Objection 2 from

Date: 09.05.2024

[with reference to application documents: ES Volume 1 Chapter 14 Flood Risk and Drainage by Mott MacDonald, and the ES Volume 3 Appendix 14.1 Flood Risk Assessment and Drainage Strategy by Mott MacDonald, and Appendix H Site Walkover Technical Note by Mott MacDonald]

Potential Negative Hydrological implications of Proposed Stadium Development on the Triangle

Figure A.15: Existing ditch west of proposed OUFC site (ditch adjacent Frieze Way carriageway)

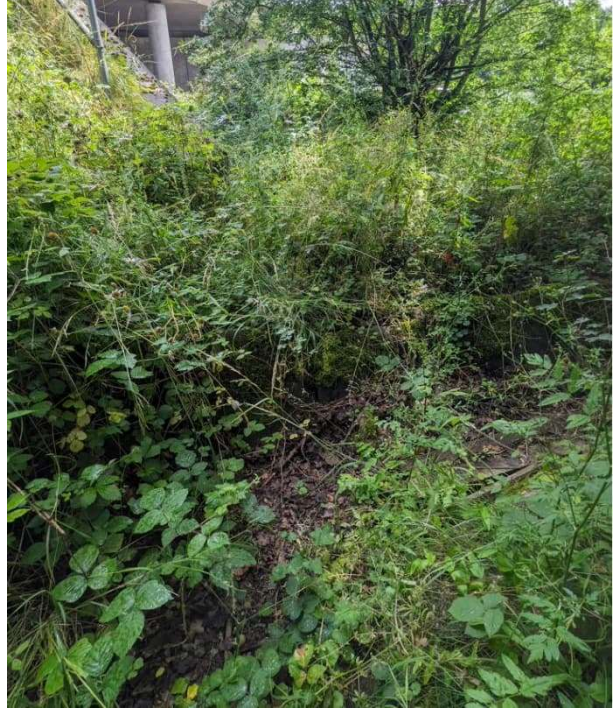
The ditches all around the site connect and drain from the lowest point on the west side ditch via an estimated 825mm diameter tube (Mott MacDonald measurement) – a concrete **culvert**, under Frieze Way to the deep ditch that runs westwards past Stratfield Brake West ancient wood section. This culvert pipe is said to be 85% blocked with silt (I agree, I have investigated and seen it so, but water still flowing out, photos below). Frieze Way opened between 1960 and 1963 and cut the original Stratfield Brake Ancient woodland into two halves. The culvert under Frieze way is approximately in the position of the original woodland ditch running along the original northern margin of the wood, before the road.

Water has been backing up in that western Frieze Way ditch going south to the culvert position because there is an access causeway to the Triangle field (maybe for agricultural machinery?) from Frieze way crossing that ditch. A drain pipe emerging from the causeway wall 30cm down shows no flow (no explanation for this) BUT I saw water bubbling up from deeper underneath the causeway so water is finding a way underneath, but flow not fast enough to lower ditch water level to north of causeway. See photos below.

This blockage & backing up (combined with extremely heavy rainfall) in that Frieze Way ditch has meant the lowest area of the Triangle site on the west side has not drained but been

Figure 8.1: Proposed Catchment Areas

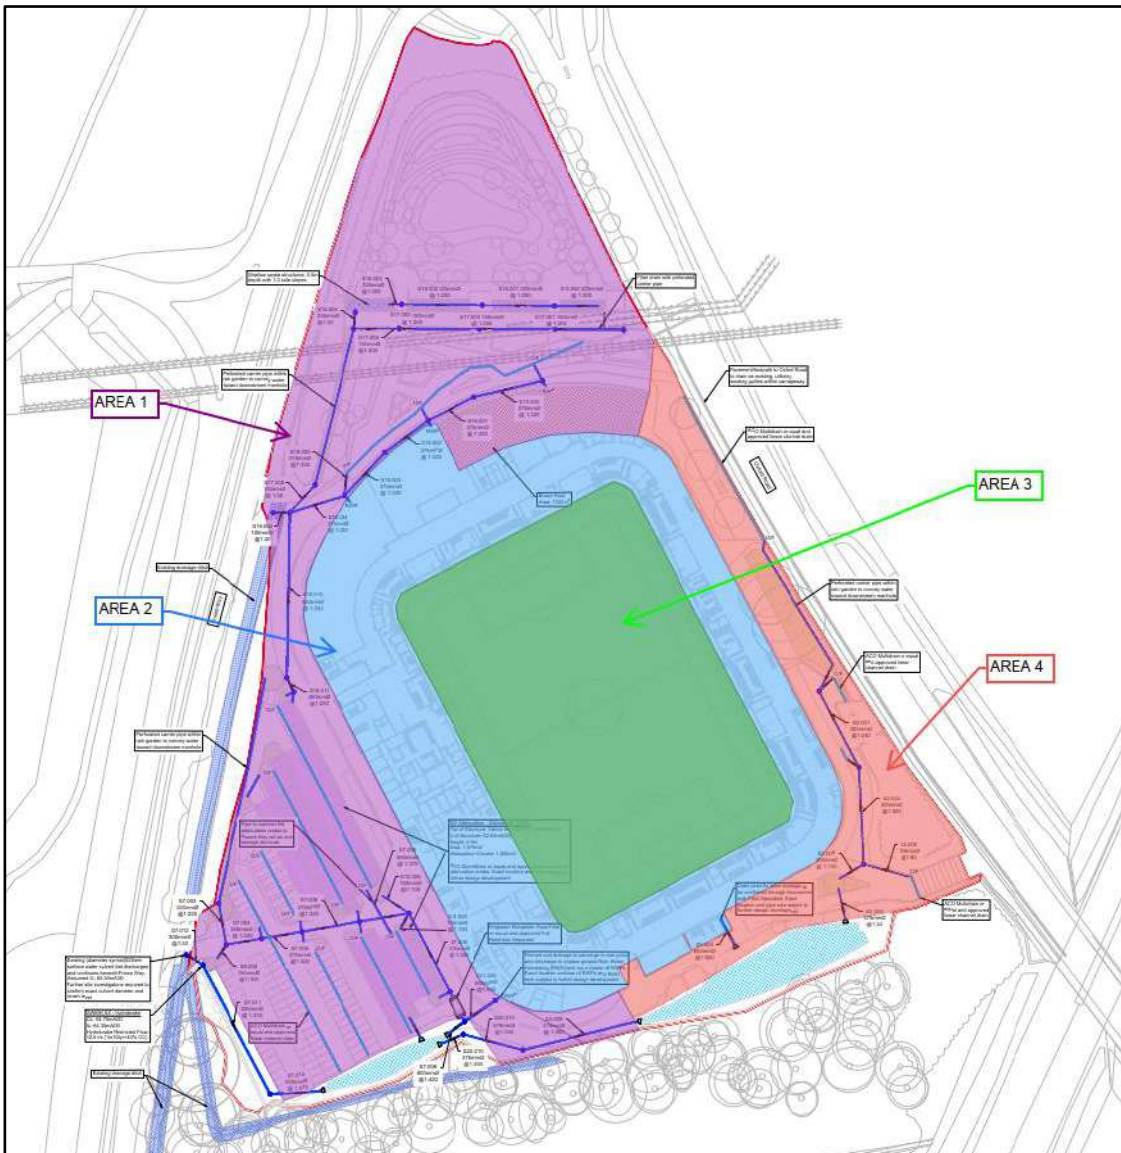
The impermeable area from development is quoted as **3.6ha so this means 76.6% of the site will be made impermeable when in operation (assuming the pitch area impermeable).**

The remaining ‘permeable’ area (although this is not much permeable on a clay soil) includes the soft landscaping areas, numerous swales, filter strips, rain gardens, ponds and attenuation basins. **Despite all these, I think rain run-off and site flooding (Pluvial flooding) is a potential big issue.**

It is stated the impermeable area will be **3.6 ha** after development (76.6% of the site). This area will have been stripped of all natural vegetation and ‘land raised’ to probably a minimum of 0.6m (discussed above) to form a level platform for building and get buildings out of floodwater by the introduction of vast amounts of waste soil/builders rubble from building activities in other sites. So this area will **no longer hold back significant amounts of rain water as it does now**, but shed much more water offsite much faster from roofs and paving/parking areas.
